EL PASO COUNTY PARKS DEPARTMENT | PARK PLANNING DIVISION

March 24, 2026

Subject: The Markets at Bent Grass -Preliminary Plan (SP-26-002)

LOT & TRACT PLAN

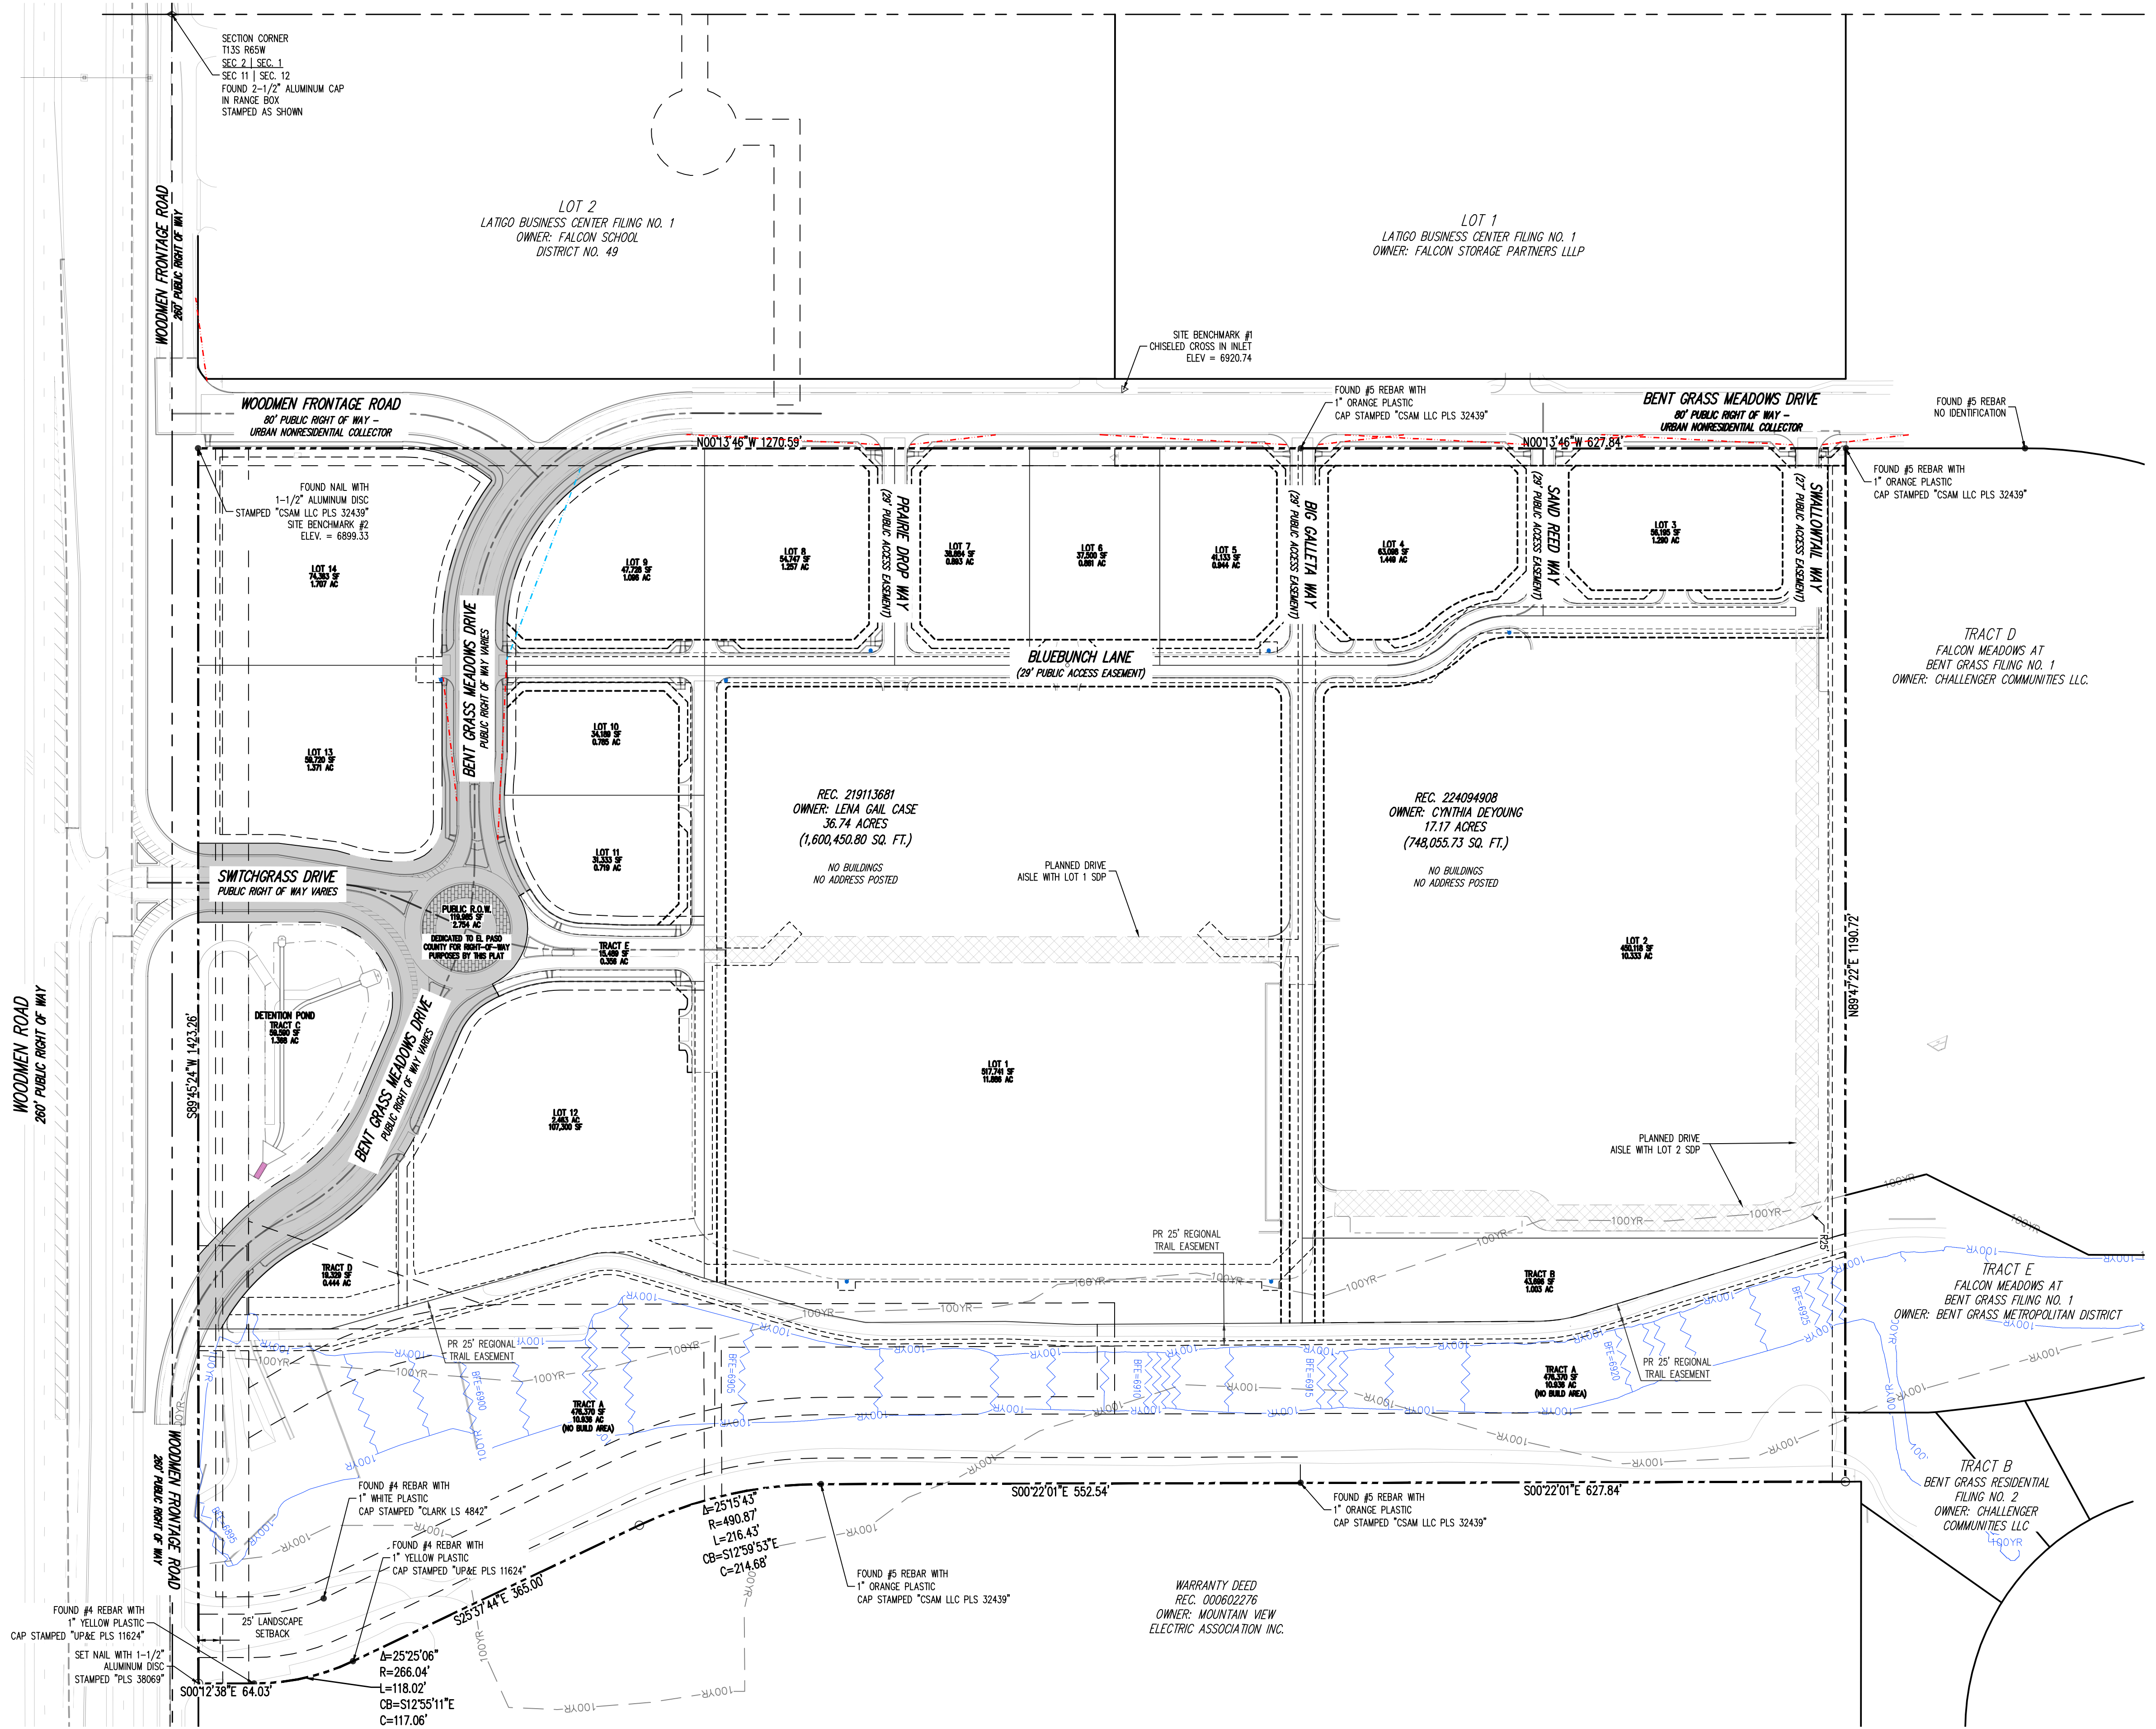
The preliminary plan currently depicts a 25' trail easement along the easterly drainage consistent with the El Paso County Parks Master Plan on page PP-3 Lot & Tract Plan. However, staff requests that a note identifying the trail easement to El Paso County be included at both the preliminary plan and final plat stages.

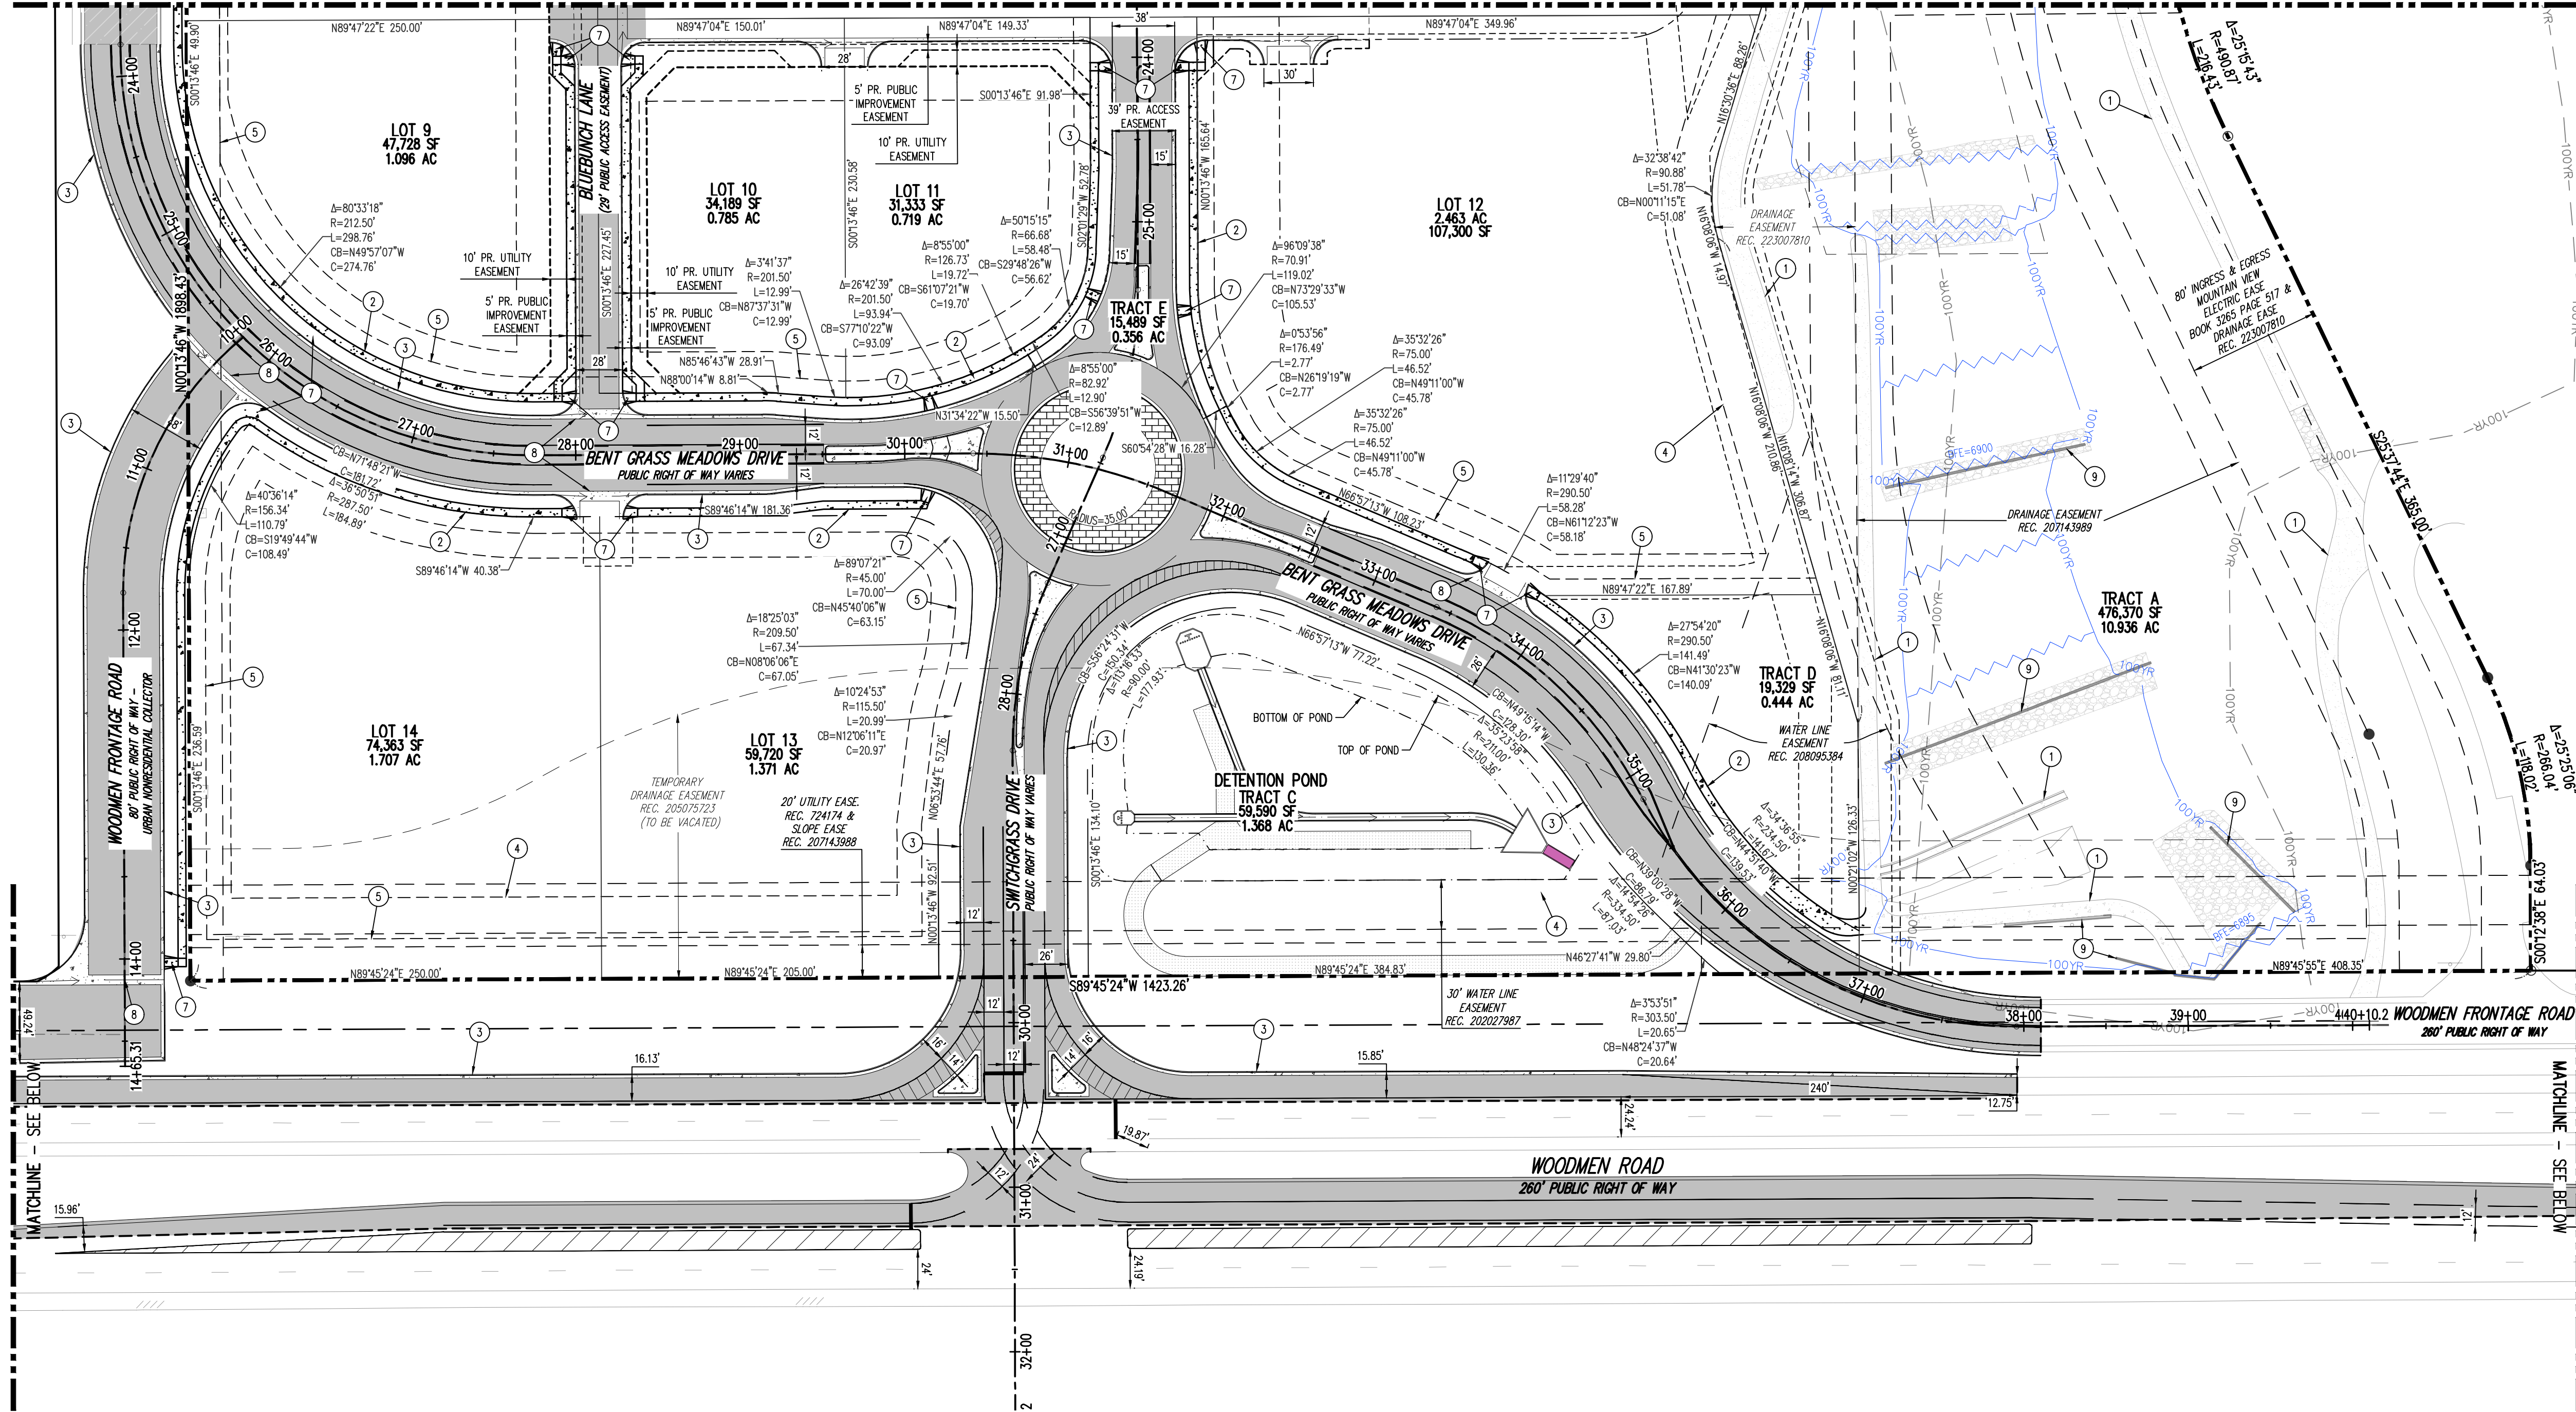
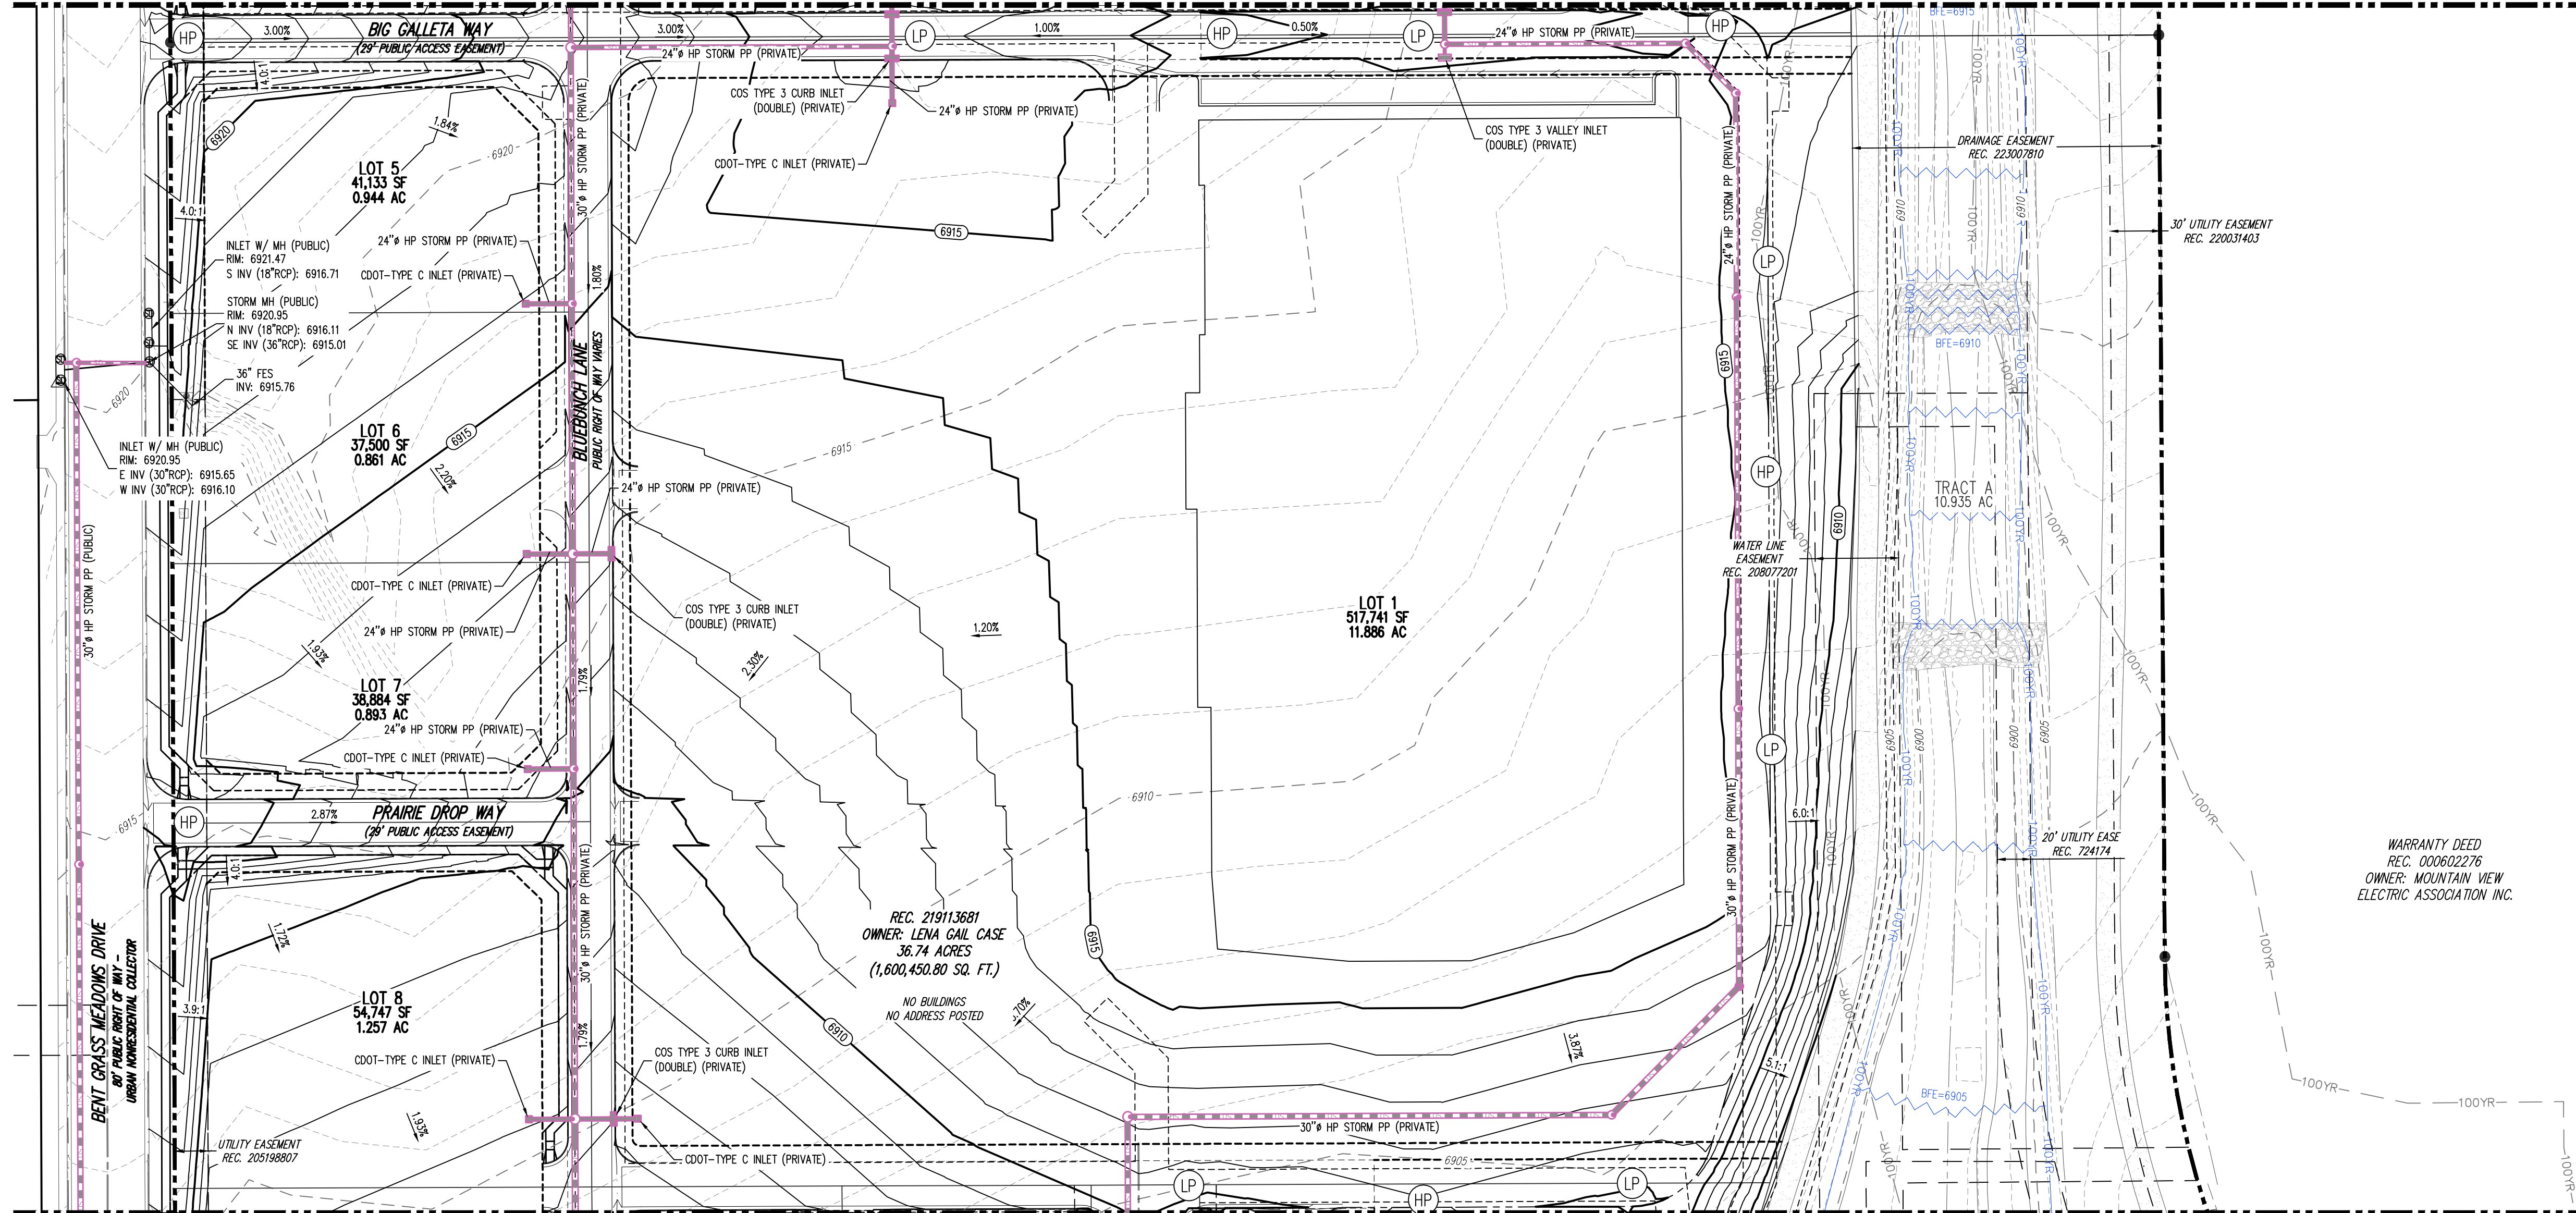
As previously mentioned, a portion of the Woodmen Hills Secondary Regional Trail exists along the Easterly drainage corridor that both connects to Woodmen Road and traverses underneath via a concrete box culvert. After reviewing the preliminary plan and associated grading plans, it's unclear how the proposed trail will connect to the existing trail. Staff requests the applicant update the grading plans to demonstrate how the proposed trail will connect to the existing trail at Woodmen Road and underpass.

The connection is in the same location as the current location. The grade will be revised as needed, maintaining a 5% max grade. The proposed connection is shown and labeled on the Site plan and grading Plan.
